Westmead Millennium Institute – Summary of Submissions

Project Application (MP 10_0050)

FLOOR PLAN
LEVEL 01 - UPPER GROUND
DRAWING NUMBER
DA-D-01
ISSUE
7

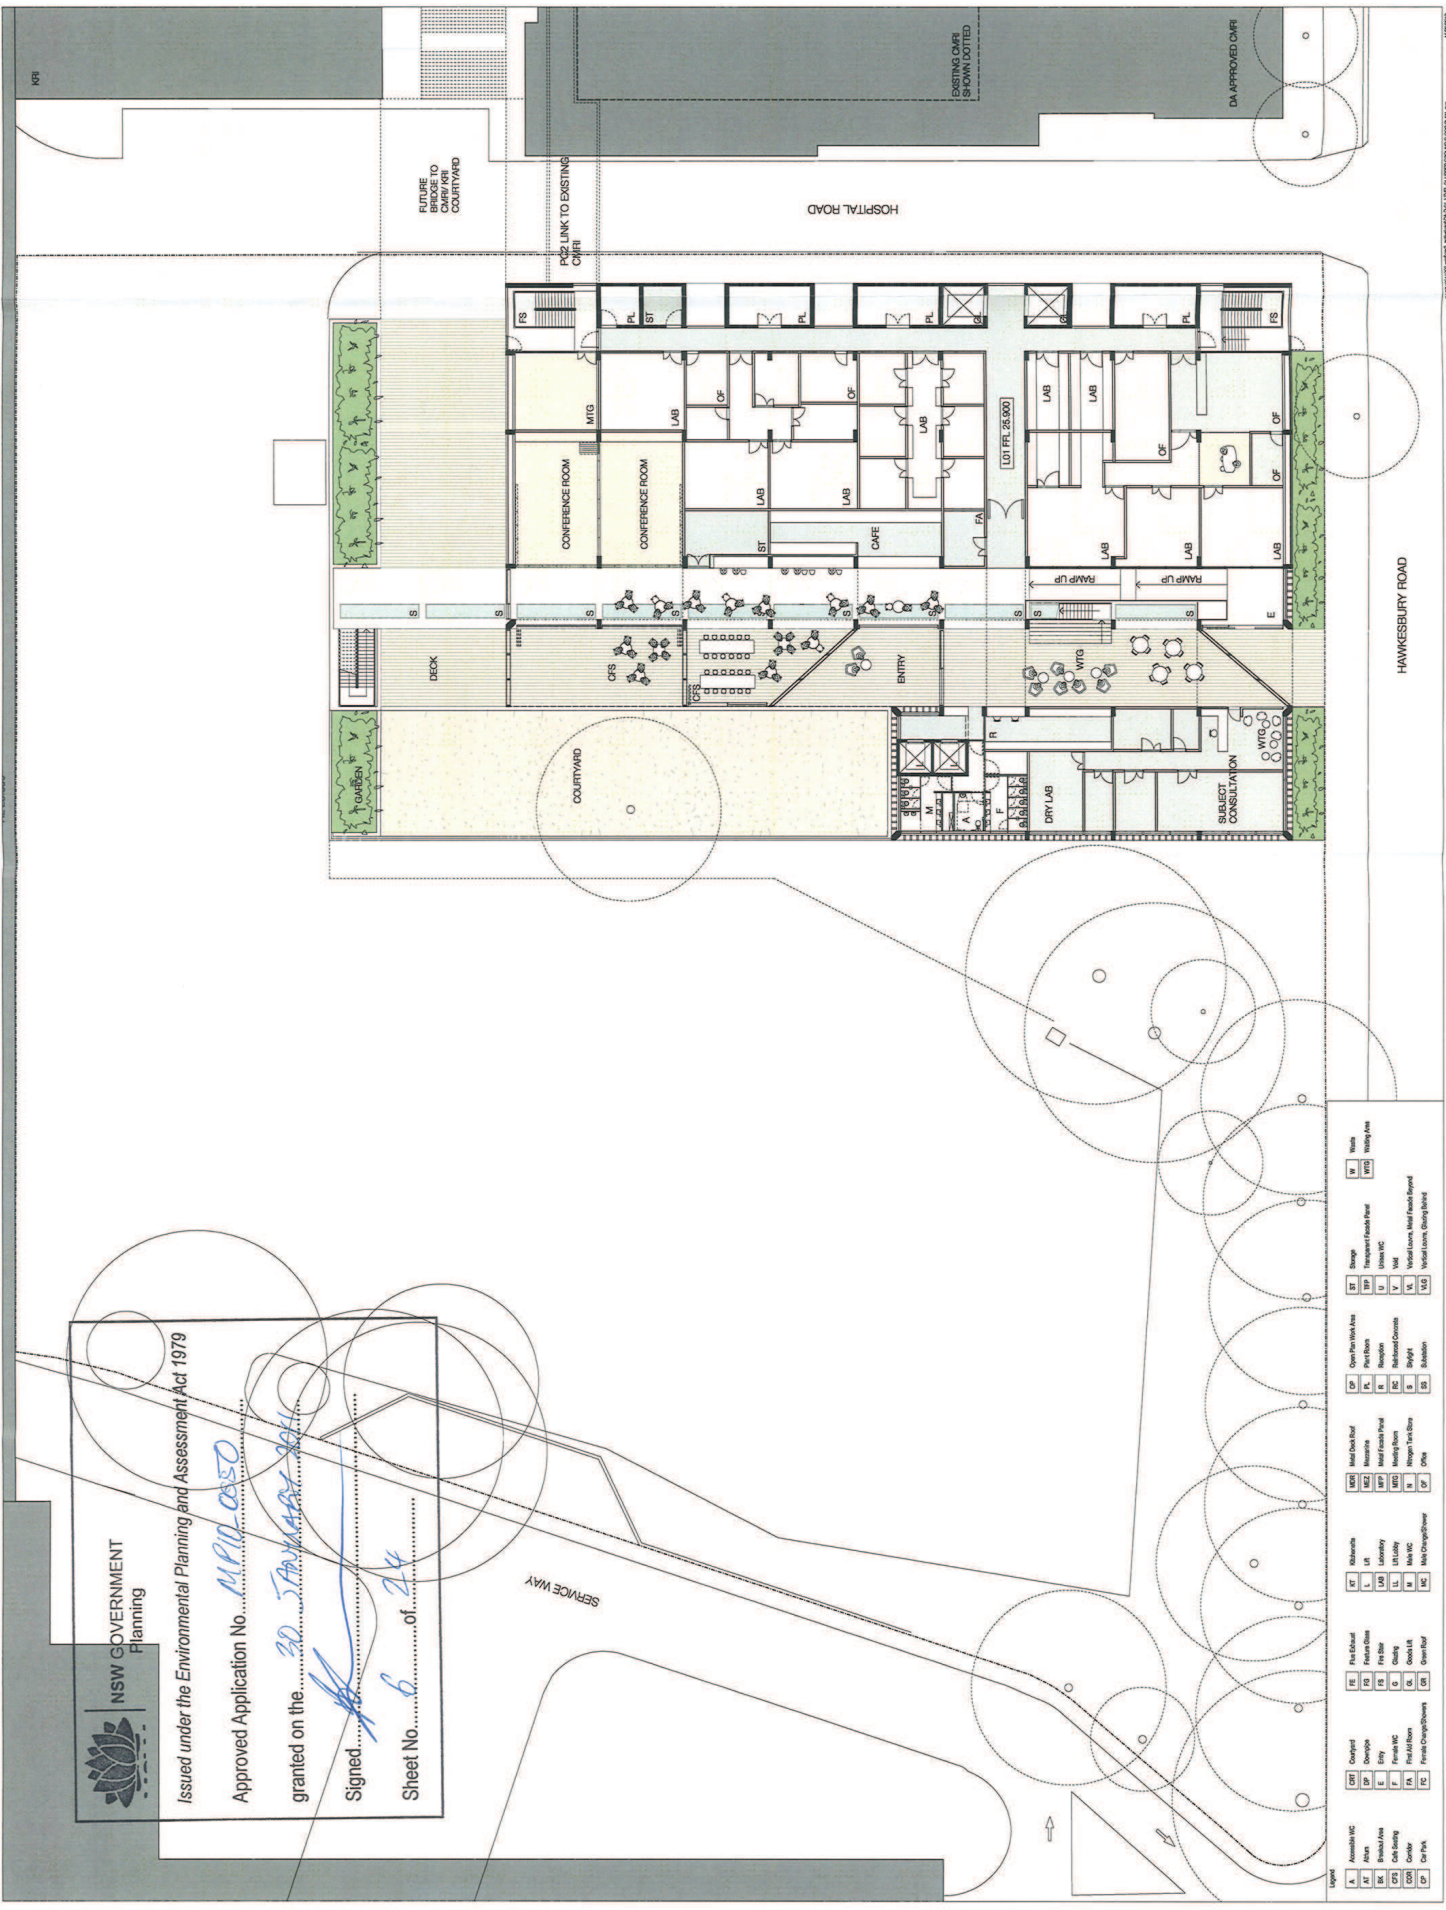
Issues Raised		Suggested Response/Action
Parramatta City Council		
1	Consideration should be given to increased opportunities for passive surveillance from within the building to both Hawkesbury Road and within the Westmead Hospital complex.	<p>Through the use of glazing (and the design of the building) the development provides significant opportunities for passive surveillance from within the building to both Hawkesbury Road and towards the Westmead Health Campus.</p> <p>The provision of a raised courtyard area towards the rear of the building will also assist with providing additional opportunities for casual and passive surveillance back towards the centre of the Westmead Health Campus.</p>
2	Given that the eight storey height of the building is above the bulk and scale of surrounding development further consideration should be given to architectural treatments to minimise the perceived bulk and scale of the development. This could include recessing the upper levels of the building.	<p>Noted. Further discussion in relation to the height of the proposed medical research facility is provided at Section 2.2 of the Preferred Project Report.</p> <p>The mass of the building has been broken down into discreet components. This is illustrated at the Hawkesbury Road elevation (refer to Figure 3 within the Preferred Project Report). Through the articulation of the central atrium and recessed stair, the building mass as a whole is broken down into two main volumes across the width of the façade. This accurately describes the building itself, which is effectively two buildings separated by the central atrium. The lengths of walls at the street elevation are approximately 21m and 10m, for the two main building volumes east and west of the central atrium respectively. Despite being higher than the approved development at CMRI (approximately 6m), the proposed building is considered to be consistent in relation to its bulk and scale – See Section 2.2 of the Preferred Project Report.</p>

SOUTH ELEVATION
DRAWING NUMBER
DA-E-01
ISSUE
6

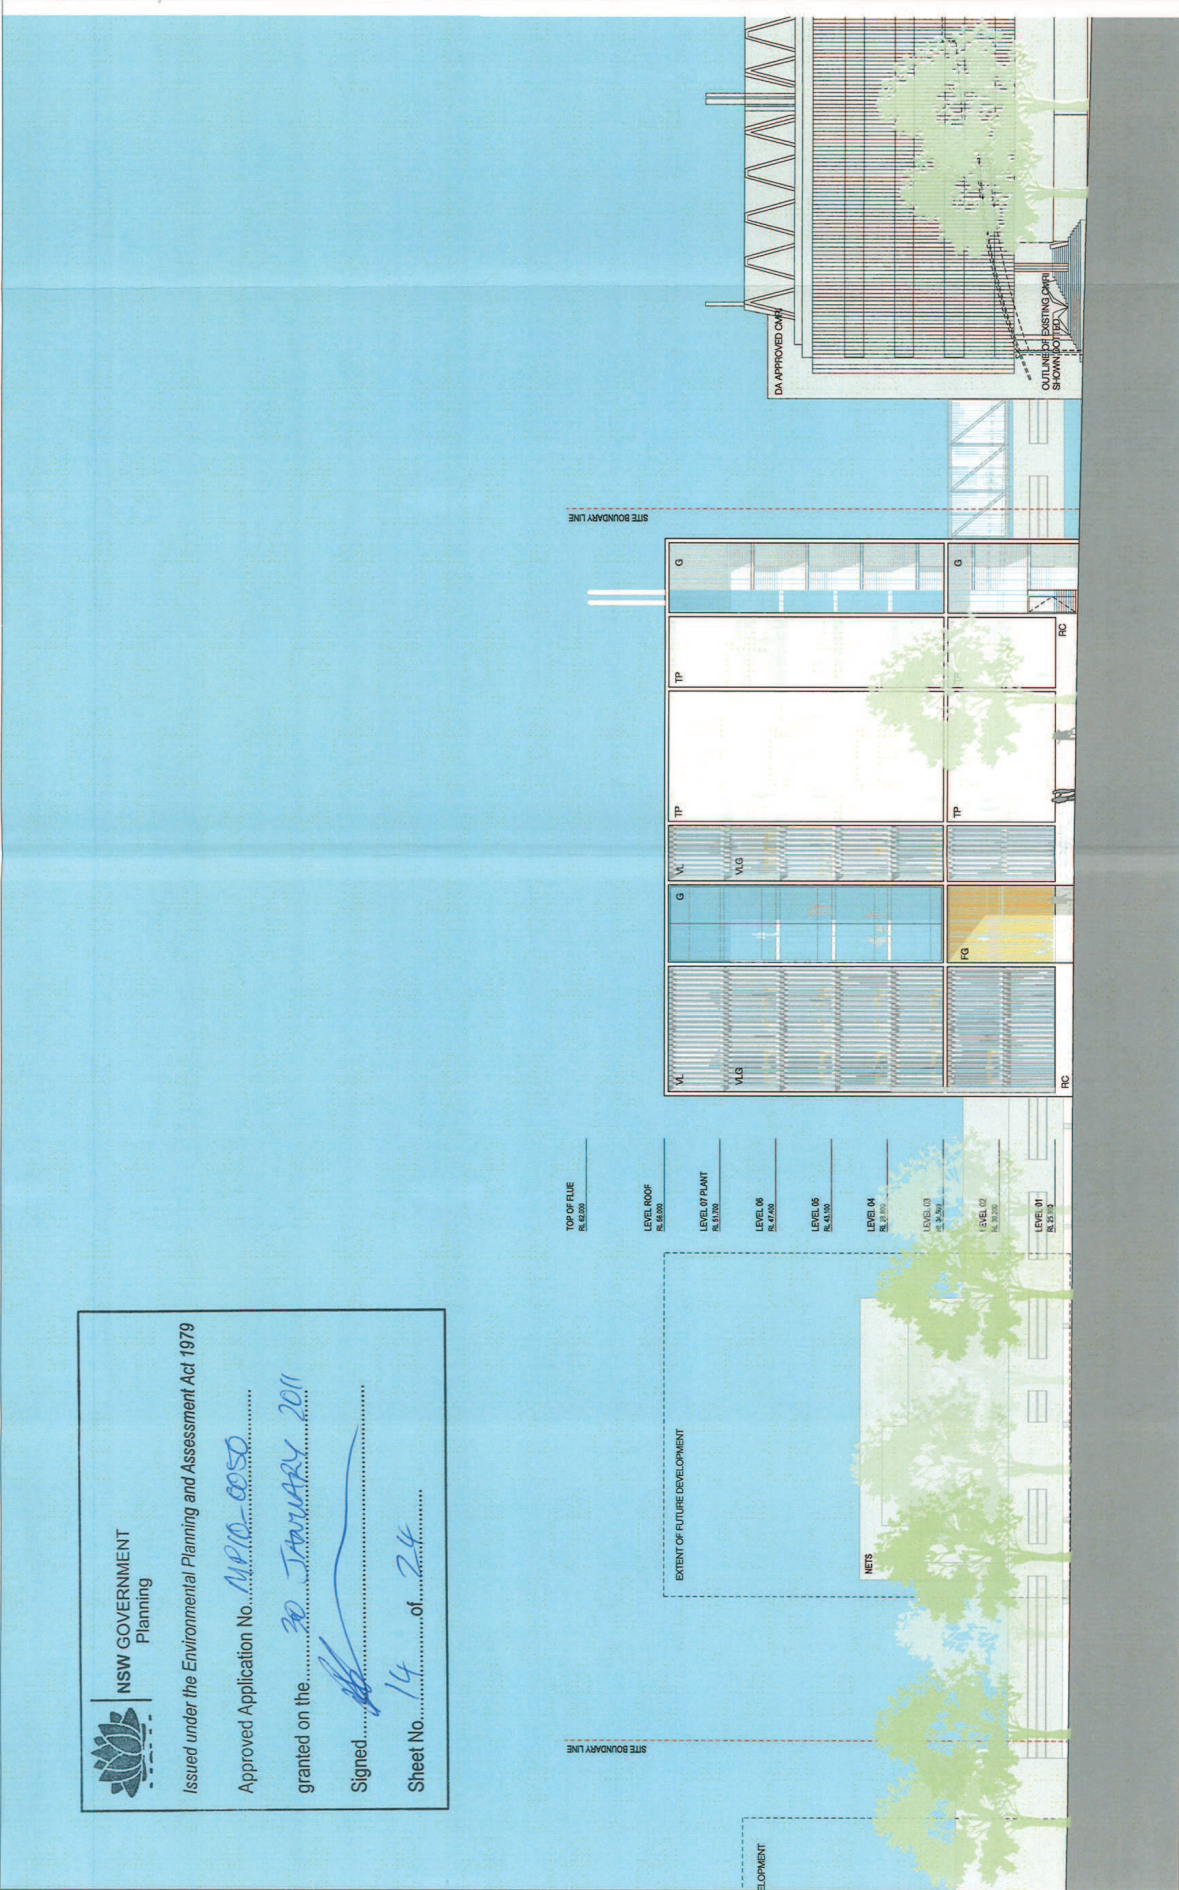
Issues Raised	Suggested Response/Action
<p>3</p> <p>Concern is raised in relation to the entry to the Westmead Research Hub (WRH) component of the proposed building. The current WRH facilities are distributed diffusely throughout the building. CMRI suggest that these facilities should have a discrete presence, with visual and functional delineation, which includes a clearly defined entry.</p>	<p>Noted. The project team have given careful consideration to the internal layout and configuration of the research hub laboratories. The building has been designed to provide for the most efficient arrangement of laboratories in relation to both servicing and travel between lab areas.</p> <p>The arrangement relies on the vertical stacking of lab areas allowing all services risers to be consolidated in a single spine at the north-eastern edge of the building. The vertical stacking also provides for connections between all lab areas via the good lifts located in the services spine. Importantly, this arrangement provides for a simple and clear connection between the upper lab areas and the core hub platforms located at the lower floors.</p> <p>Focusing the research hub laboratories towards the north-east, with a number of physical connecting linkages, provides visual and function recognition that the laboratories form part of a wider network within the Westmead Research Hub.</p> <p>Notwithstanding, the proponent commits to continue to consult with CMRI as part of the detailed design stage and investigate opportunities for improving the relationship of the two research facilities, and in particular review how the Westmead Research Hub facilities are distributed throughout the building.</p>
